Lawful Development Certificate for a Proposed Use or Development

Development: Lawful development certificate for the proposed construction of a single storey rear extension to the dwelling house.

Location: 40 Greencourt Drive Bersted PO21 5EU

Site Plan - 40 Greencourt Drive Bognor Regis

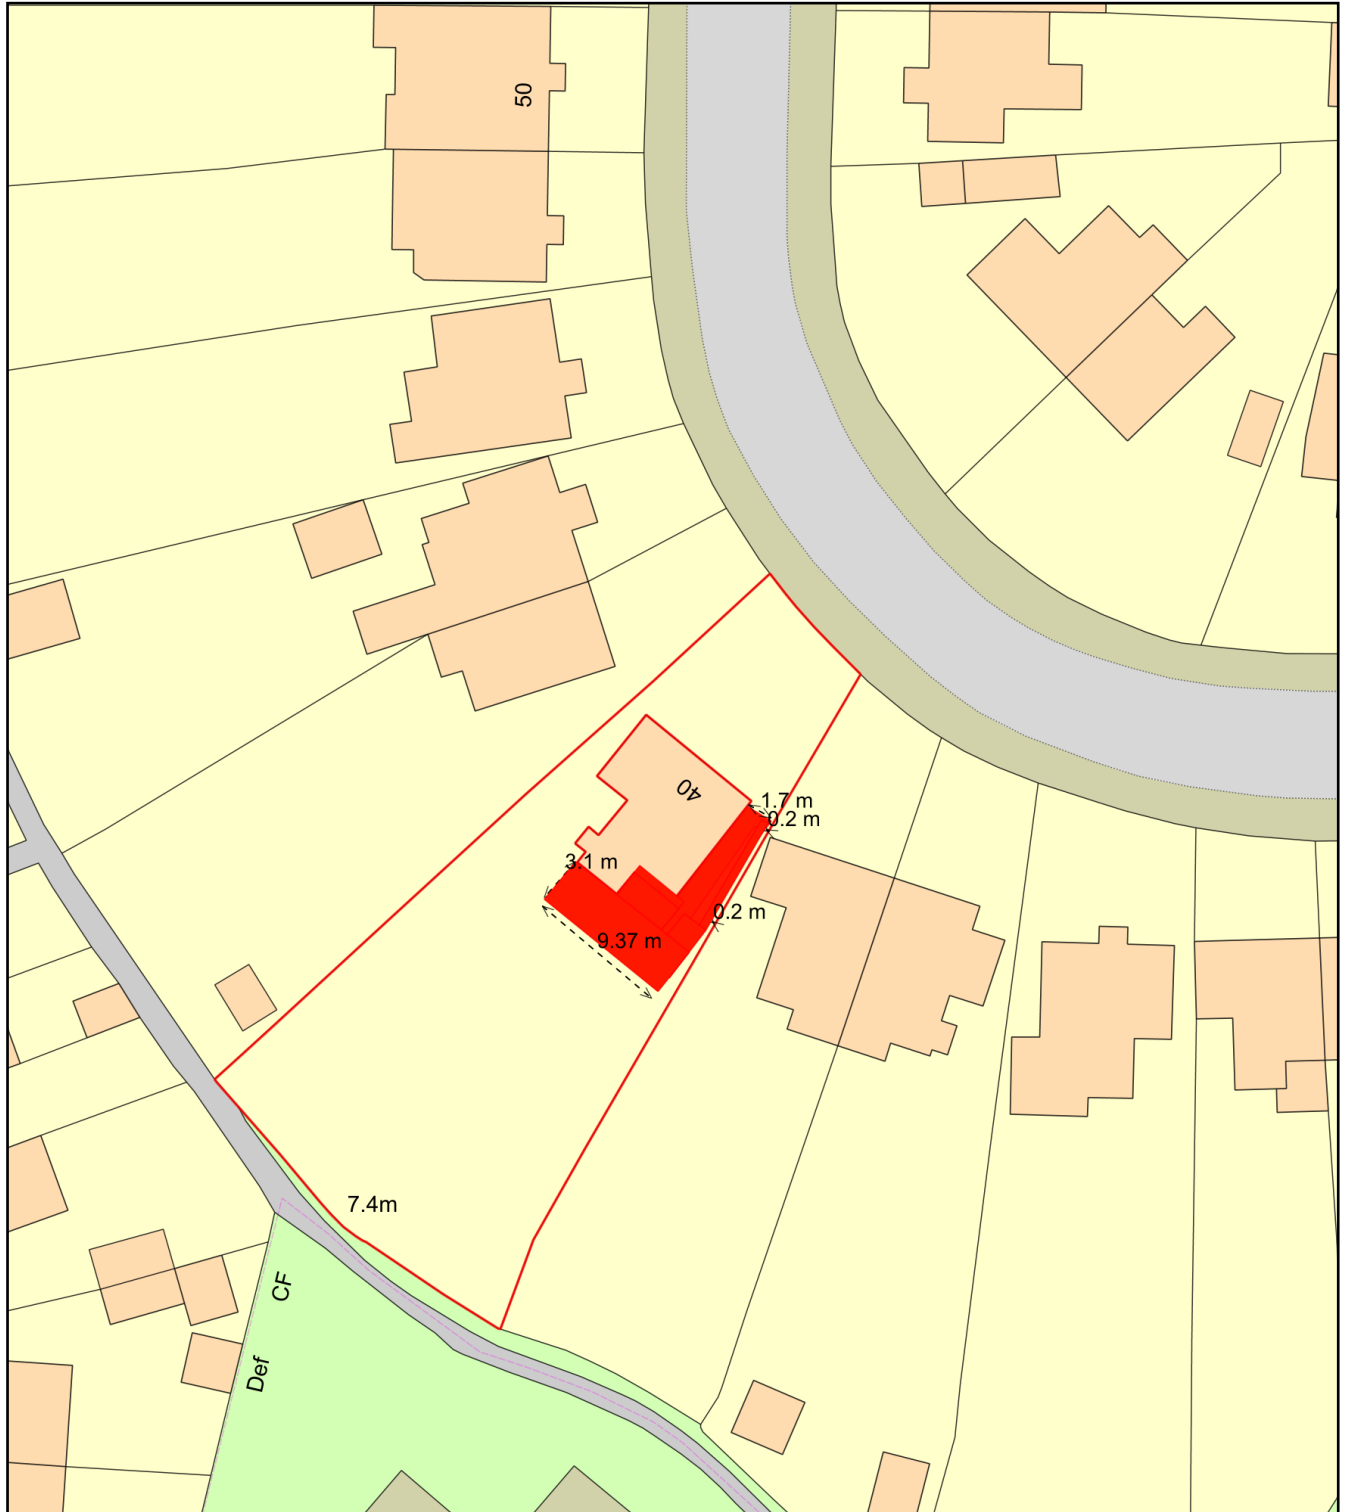
The block plan indicates that a side extension is proposed for this application. Please confirm that the side extension does not form part of this application.
